From: [REDACTED]
Sent: 08 May 2026 16:30
To: Planning
Subject: Planning Application No: 3/2026/0292
Attachments: IMG_1555.jpg; IMG_1552.jpg

With regards to Planning Application No: 3/2026/0292 – Ashgreen House, 1A, Somerset Avenue, Wilpshire, BB1 9JD.

I hereby give notice that I DO NOT AGREE TO & STRONGLY OBJECT TO the above proposal for the Change of Use for the dwelling in to a Childrens' Home from being granted.

proposed ground floor plan

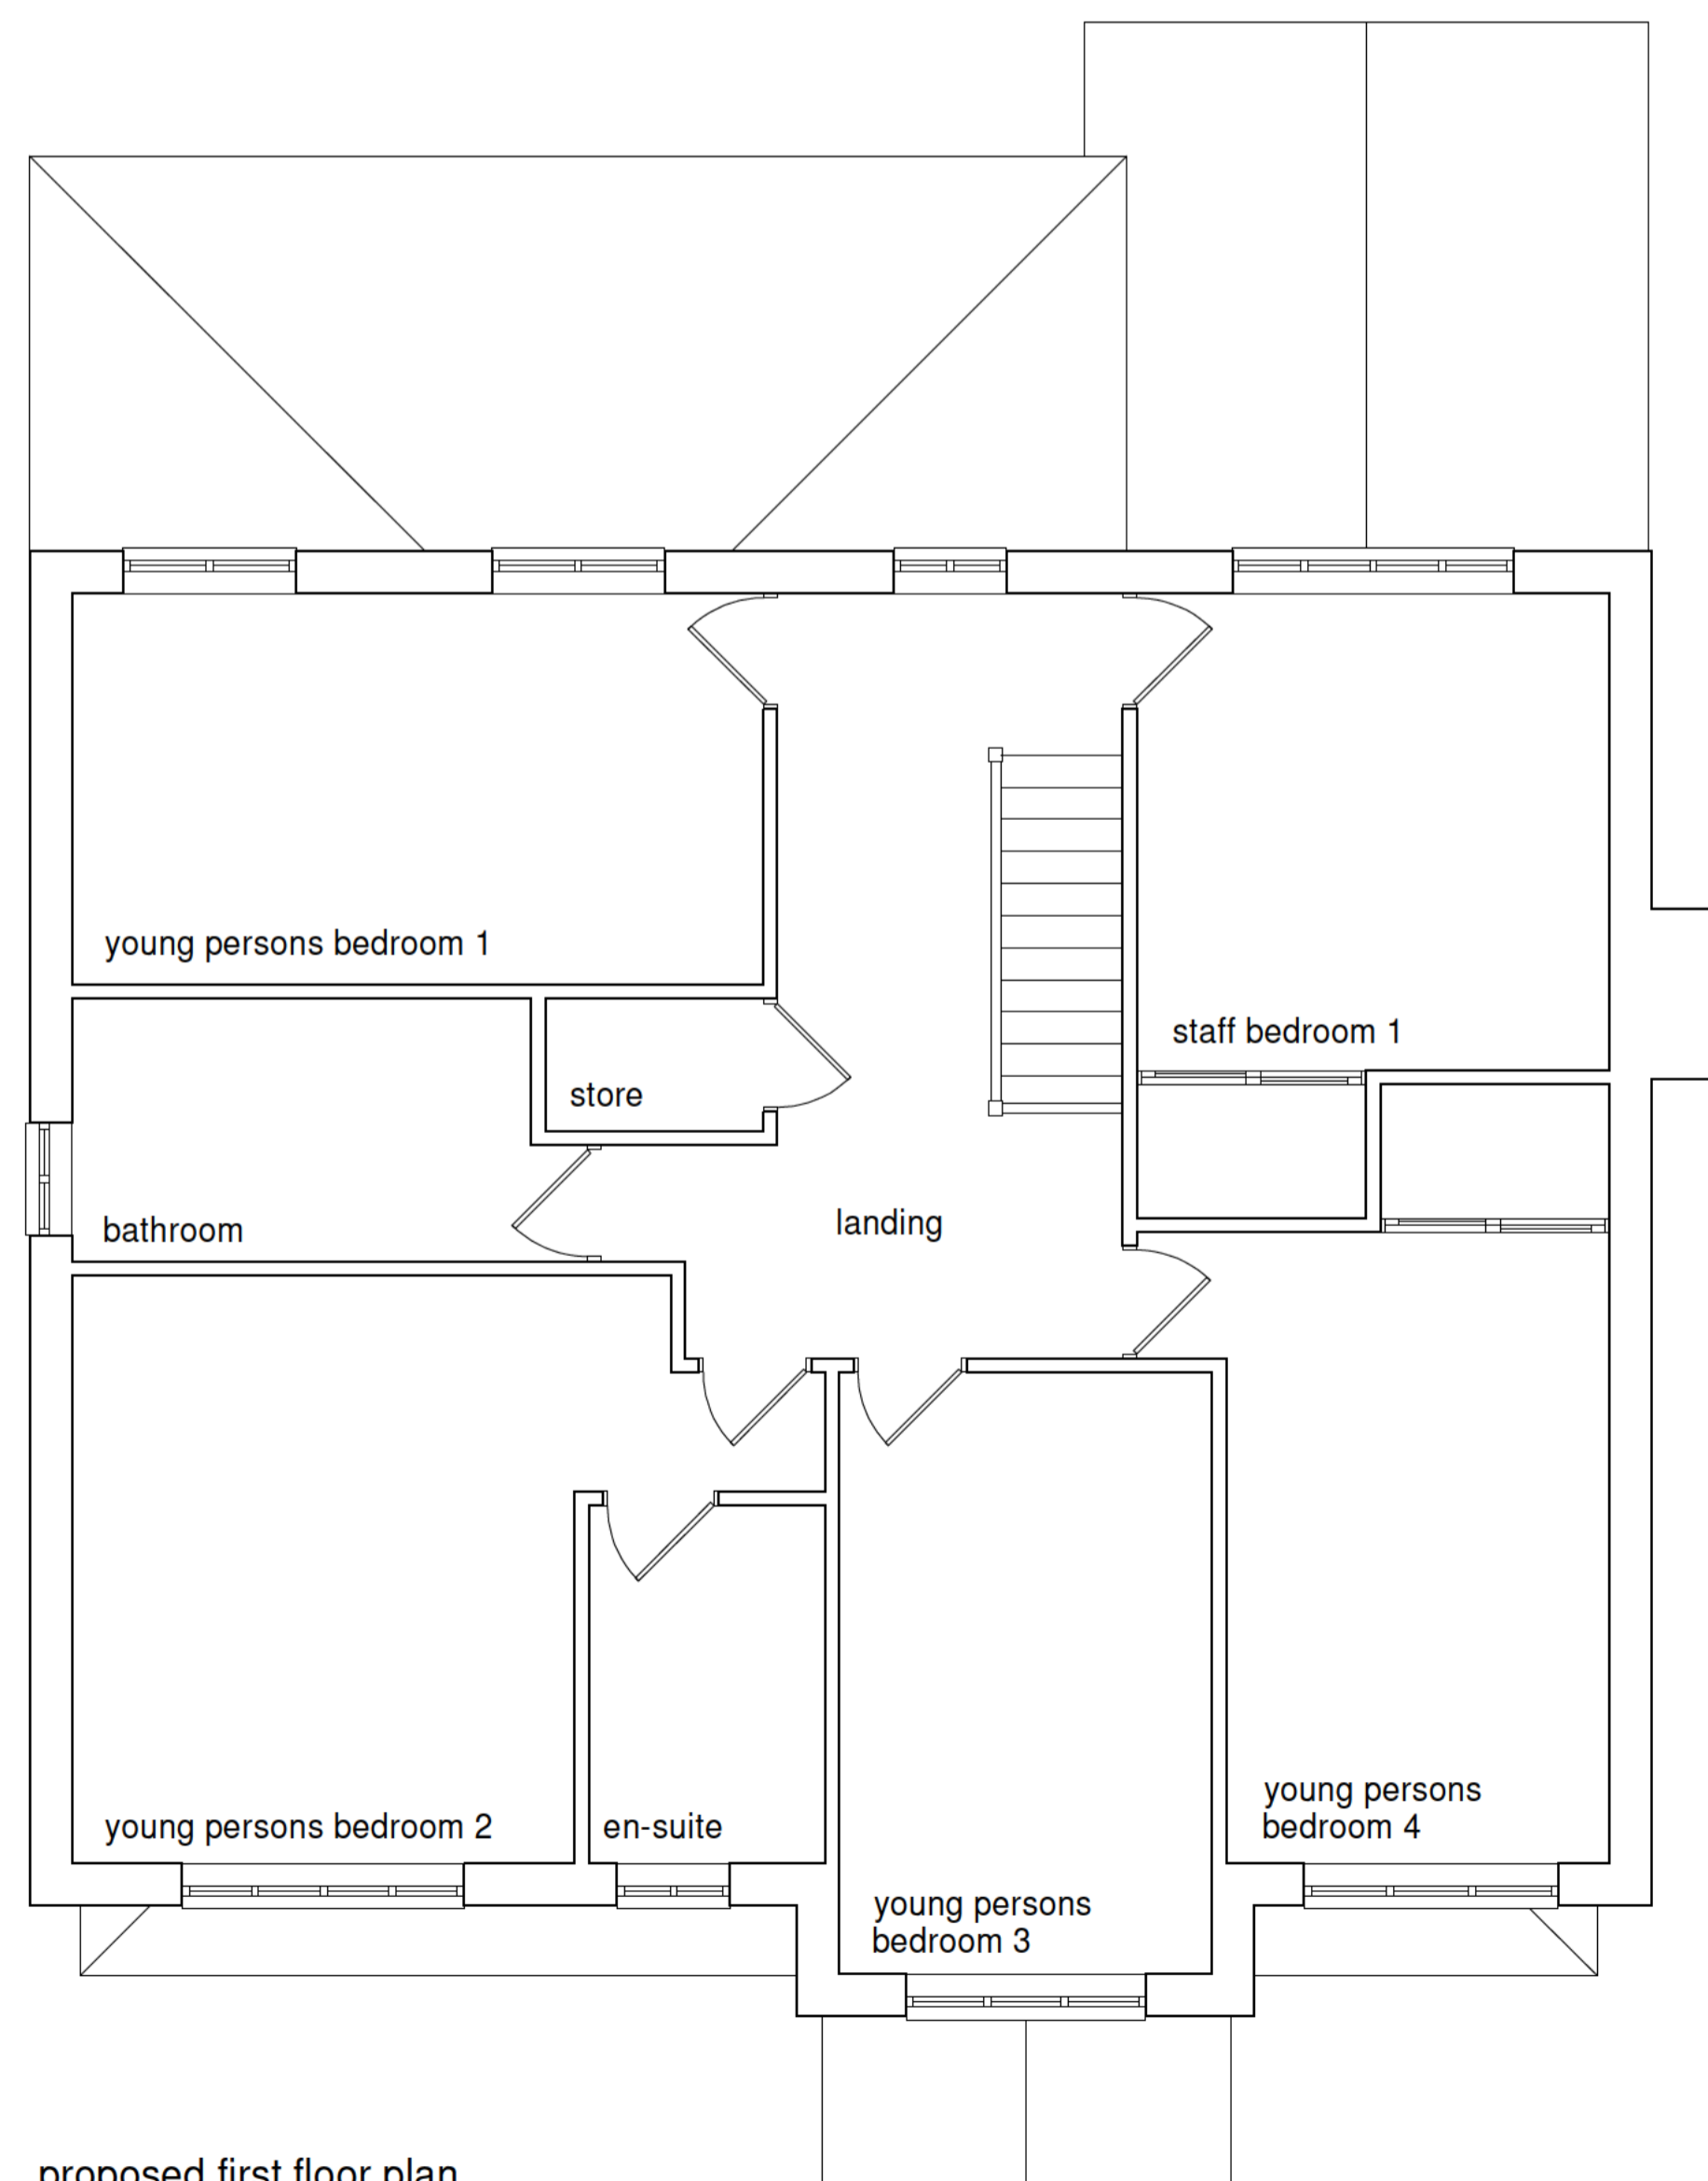
Planning Statement – 2.2 *“Four of the bedrooms will be occupied by children. The downstairs study will be converted to a bedroom, so each member of night staff will also have their own bedroom.”* – **This statement does not match the Drawing Reference 26.0292 Proposed Elevations & Floor Plans for the Proposed Development.**
